East Lindsey District Council Response to ExA First Written Questions

4.10 Indicative Central Construction Compound Layout

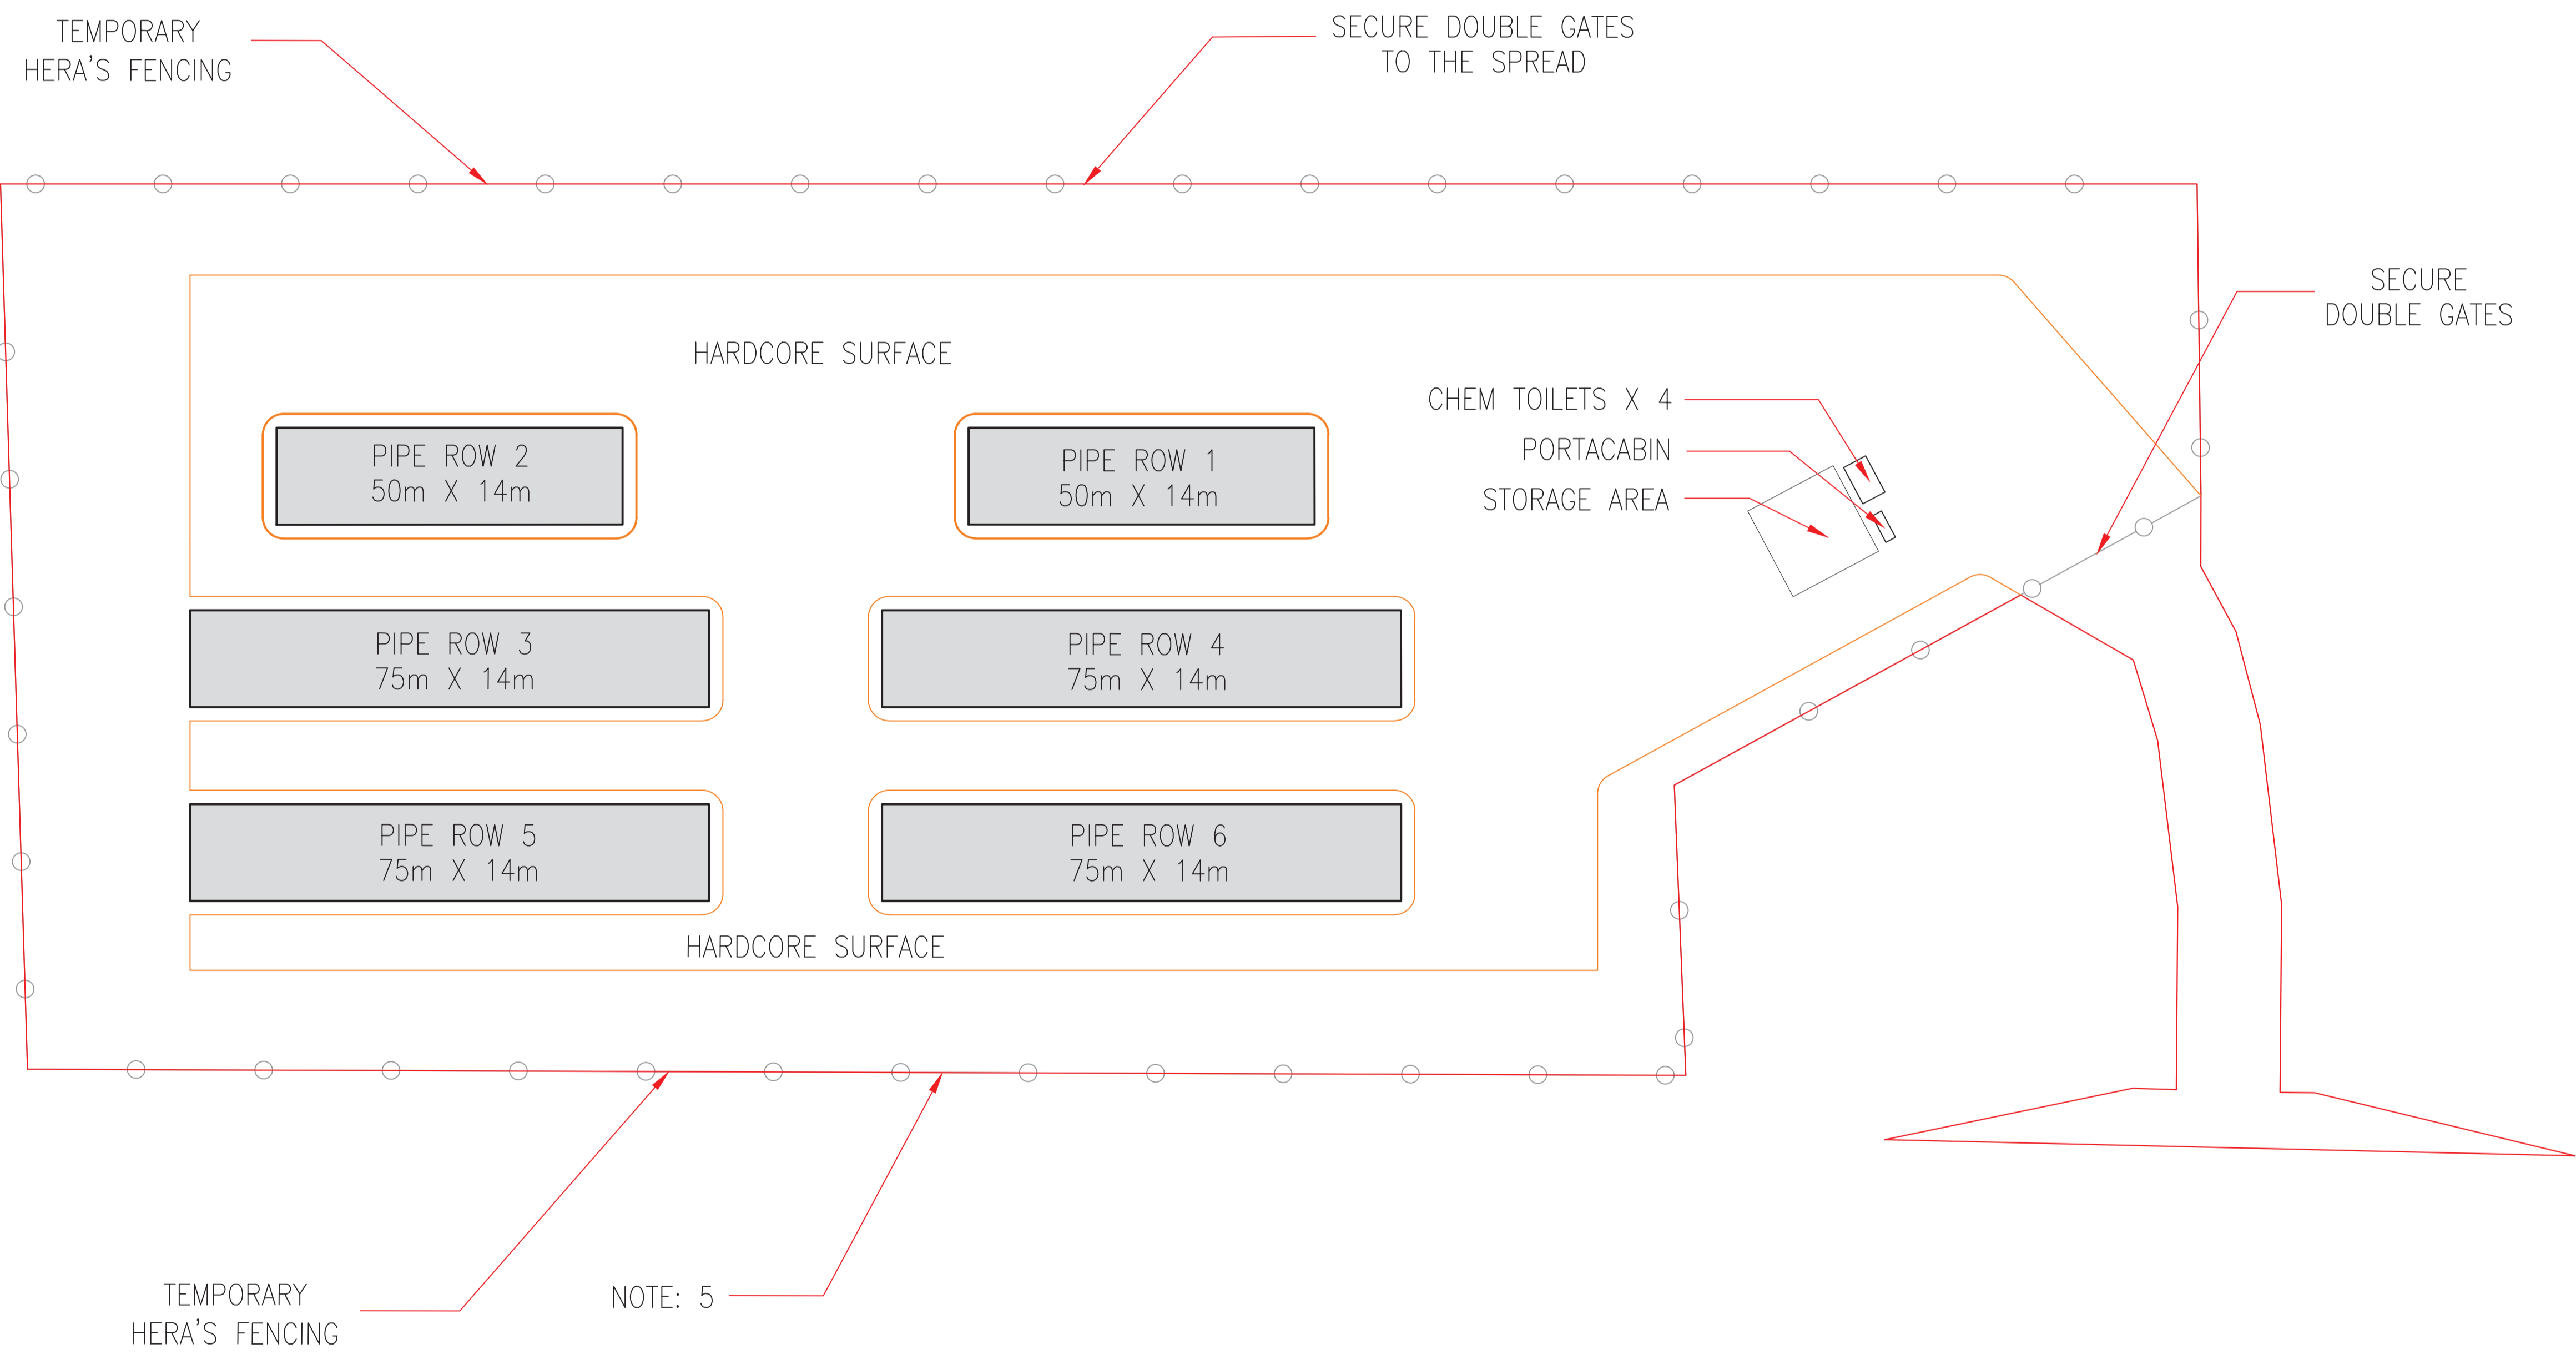
<p>anticipated." It is accepted that compound setup noise will be minimal; however, this does not assess potential noise effects from the use of the construction compound. Depending on the activities which will be undertaken when the compound is used, the timings of those activities and the overall length of time it will be used for, noise effects at nearby receptors could be significant. The assessment should be revised to include noise from the use of the Southern construction compound, or else provide further evidence as to why an assessment is not required. Clarification is also required on whether the compounds will be used at night.</p> <p>Para 13.4.7 of the assessment (which is in the construction assessment section) presents an assessment of maintenance venting impacts; this is understood to refer to maintenance of the operational pipeline and this section should therefore be moved to the operational assessment section. This paragraph states that "The venting of CO2 will be undertaken at a rate whereby the noise at the nearest Noise Sensitive Receptor will be no greater than 10 db above daytime background levels, which are 38 dB at Theddlethorpe. These levels will be back calculated to the perimeter of the facility and monitored as such. It is therefore confirmed that venting noise would be Not Significant." The operational noise assessment methodology should be updated to describe the method used for assessment of effects during maintenance. It should be clarified what noise level parameter the "noise at the nearest Noise Sensitive Receptor" is referring to. Further details should also be provided on the monitoring and calculation procedures that will be used to demonstrate compliance with the proposed limit and a demonstration that the proposed limit can be met, including any mitigation that may be required.</p>
